Recommendation Report for Planning Permission for Works or Extension to a Dwelling

REF NO: K/23/21/HH

LOCATION: Mimosas
Gorse Avenue
East Preston
BN16 1SF

PROPOSAL: Erection of part 2 storey and single storey rear extension and first floor balcony

Existing survey
was undertaken
by others
including heights

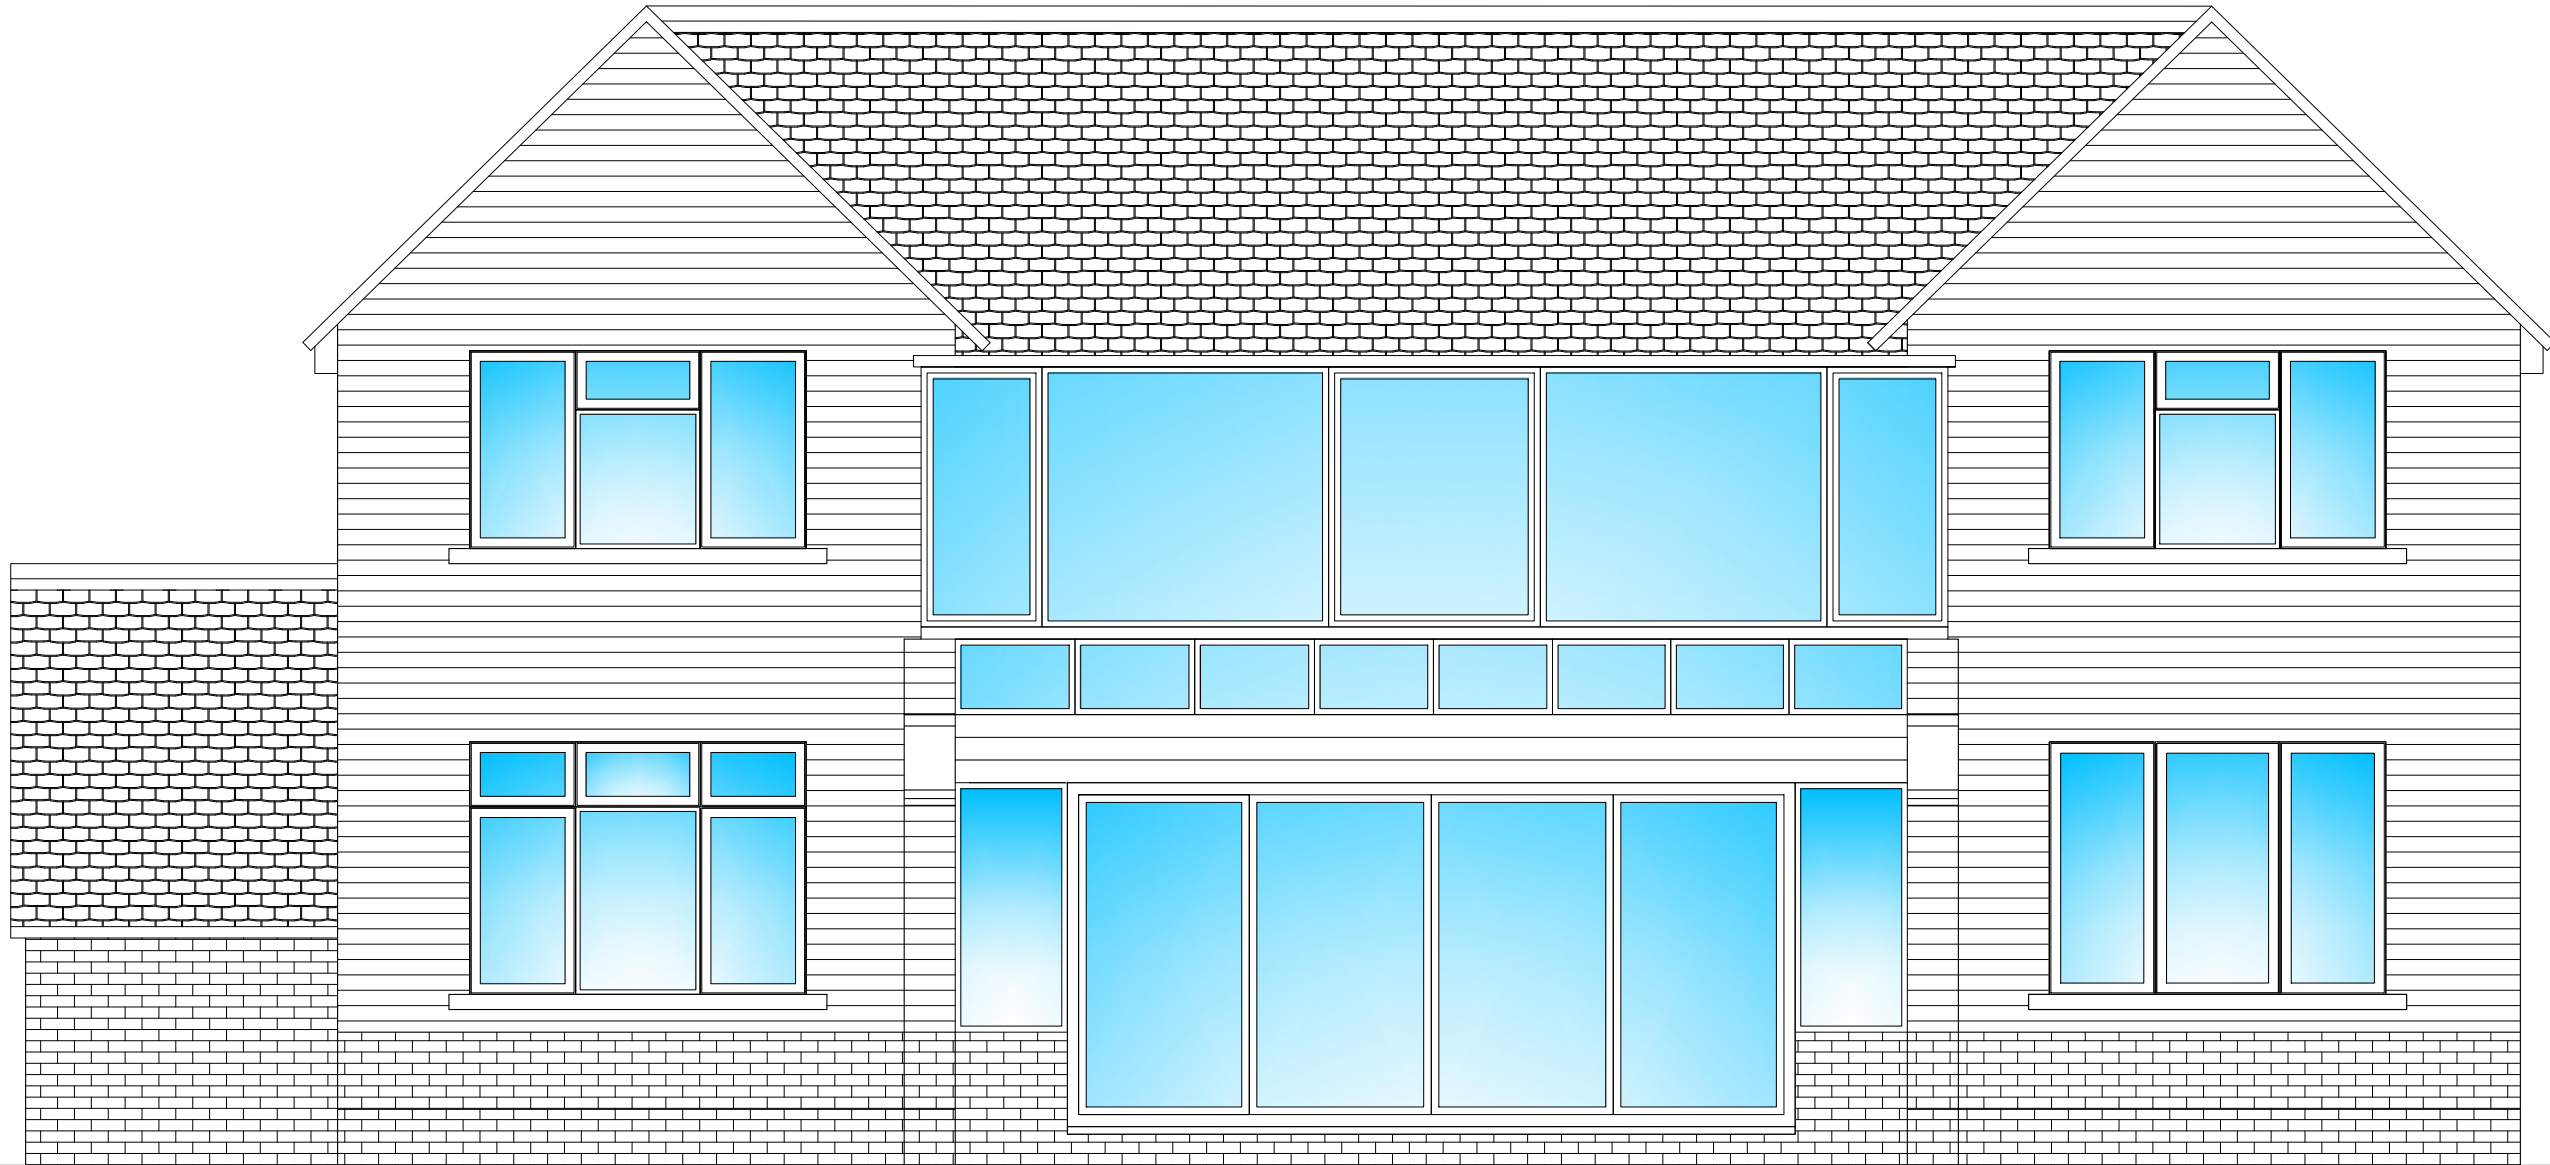
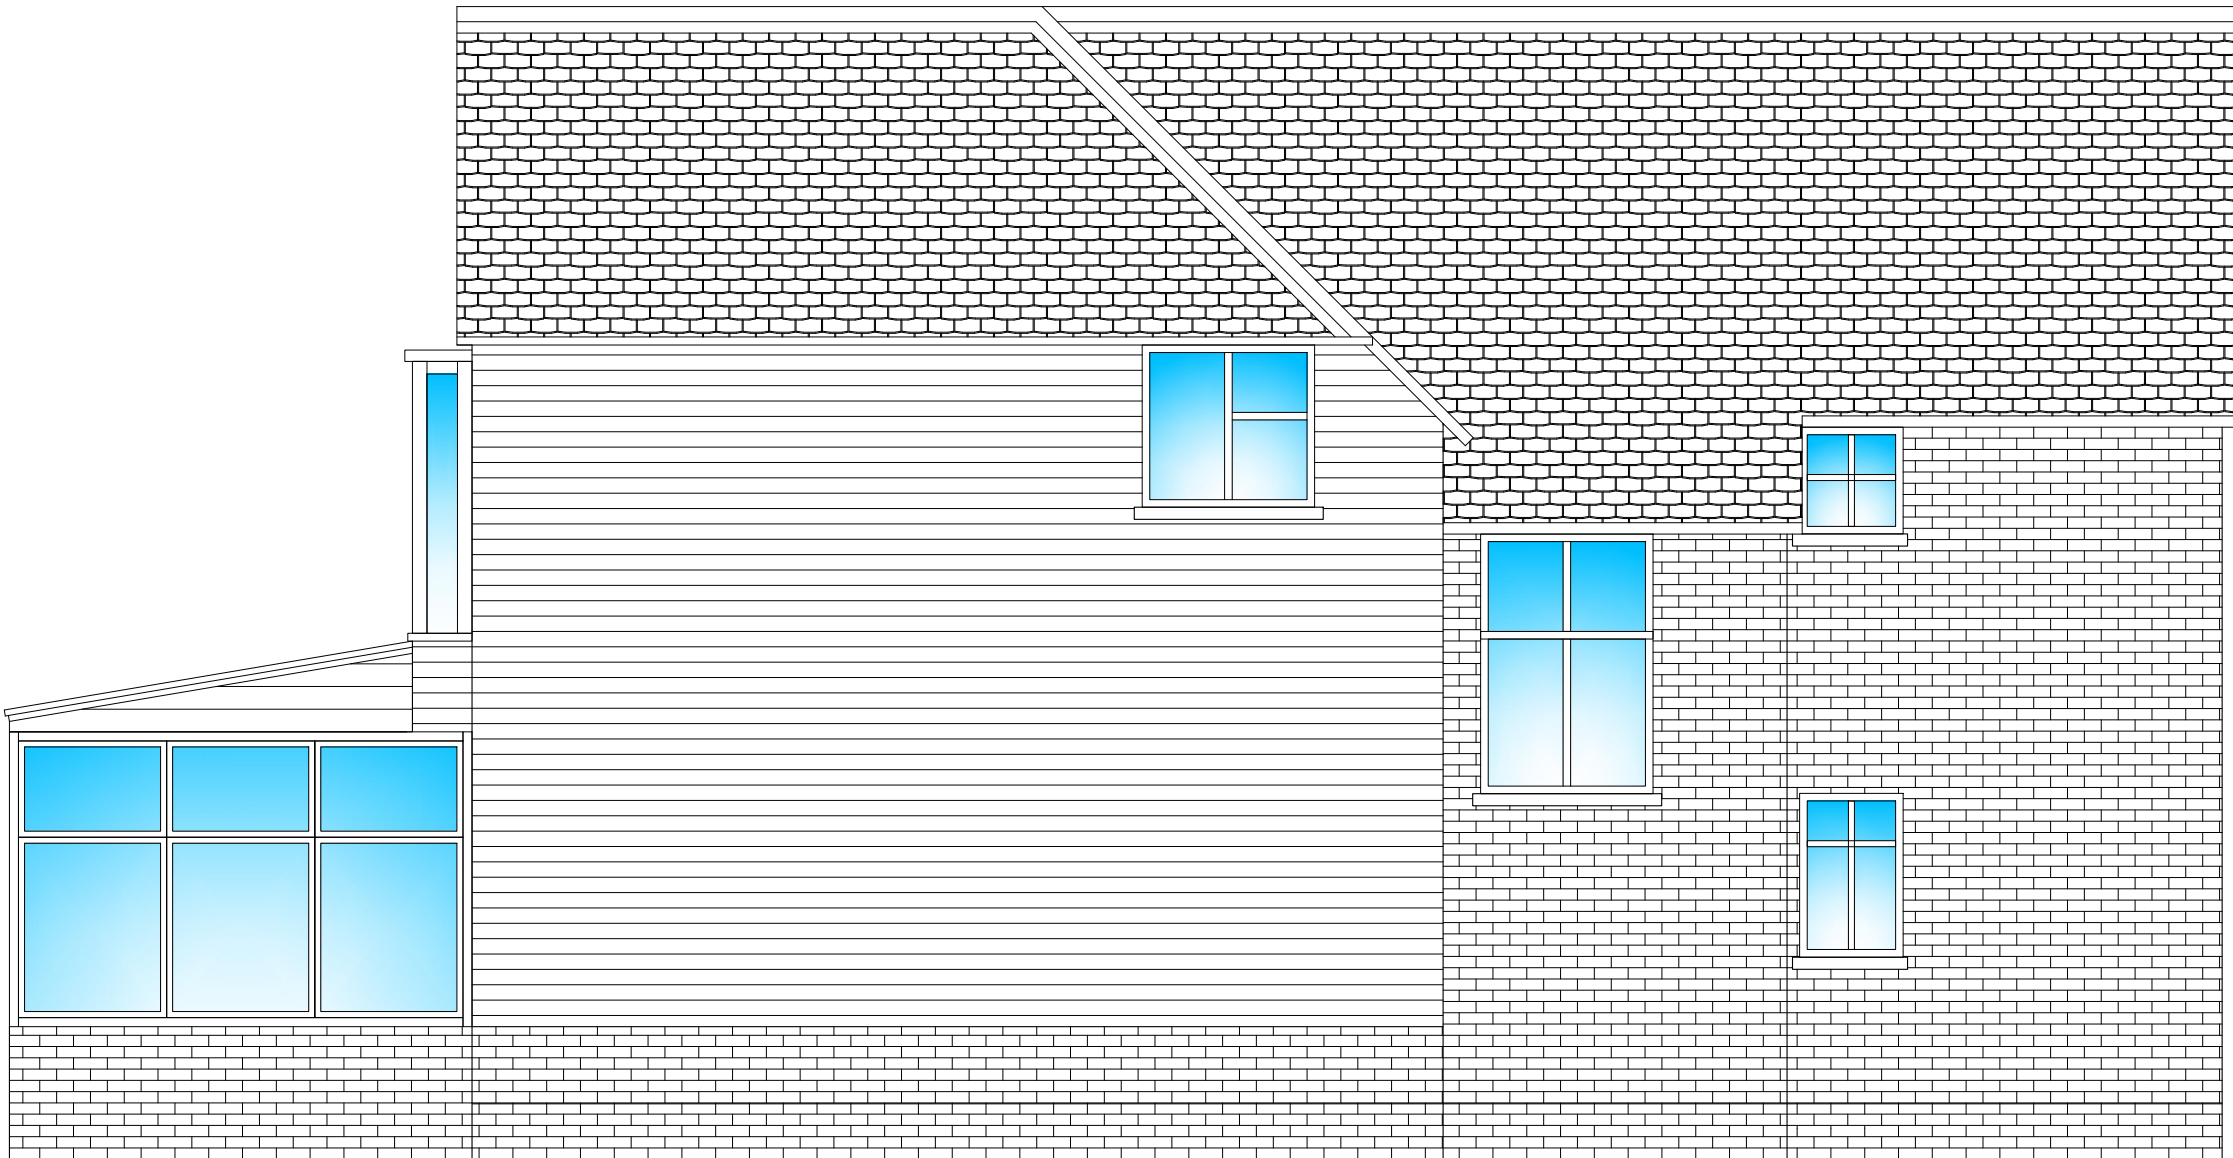
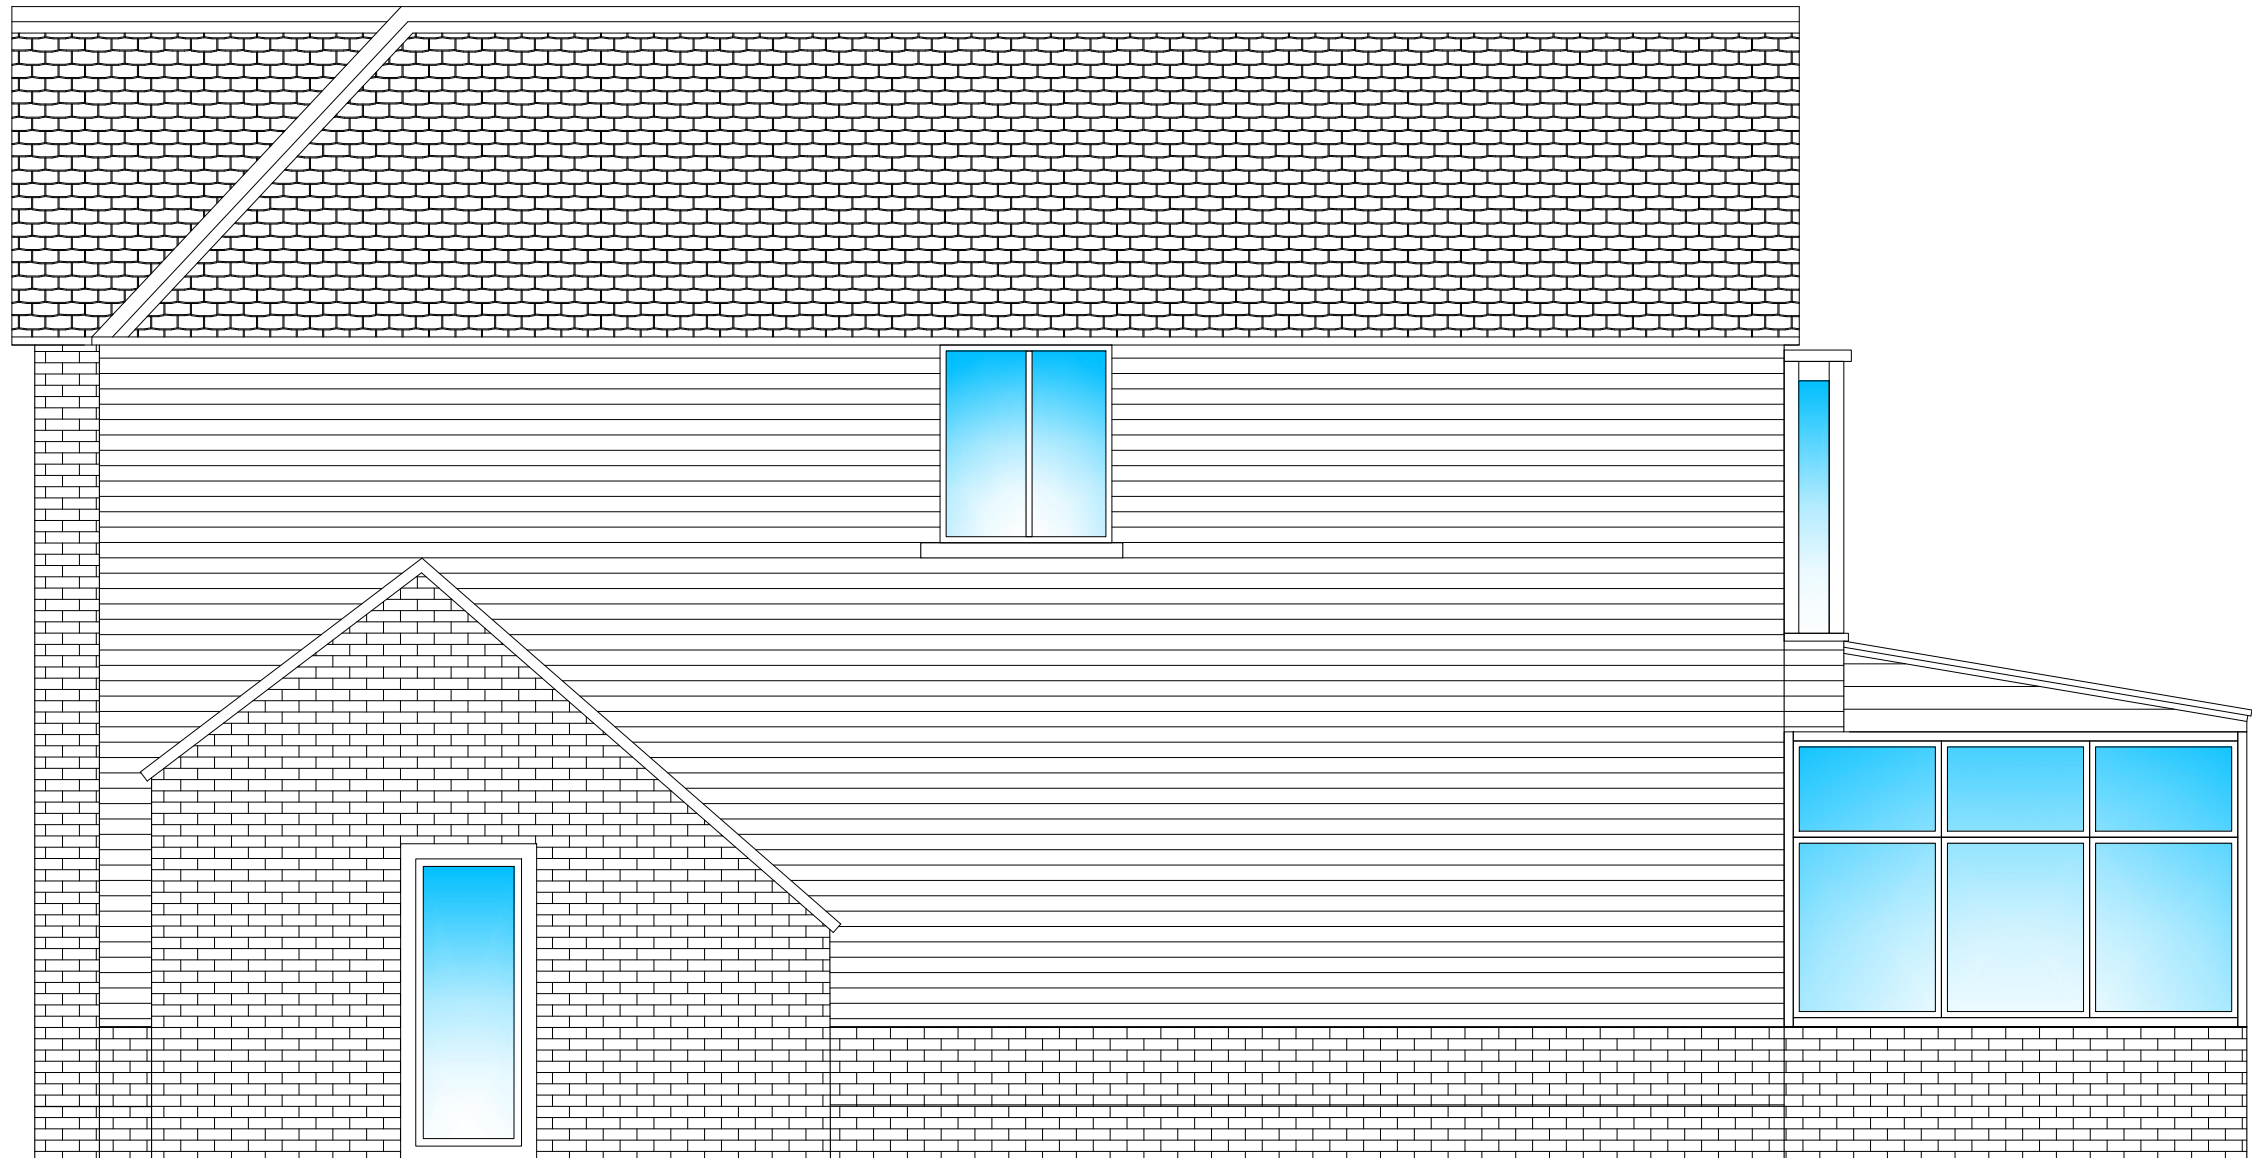
Kingston Parish Council: Objection: ridge height of the extension considerably higher than original, but no heights given for the elevations, only the comment "existing survey was undertaken by others, including heights". rough calculations put it higher by nearly 1 metre (900 mm / 35 inches) to the original roof. - Spring Tide could be overlooked from the new balcony. Kingston Parish Council request, if this application is approved, it must with the provisos: 1. The ridge height is lower or in line with neighbouring properties, and 2. The balcony does not overlook adjacent properties
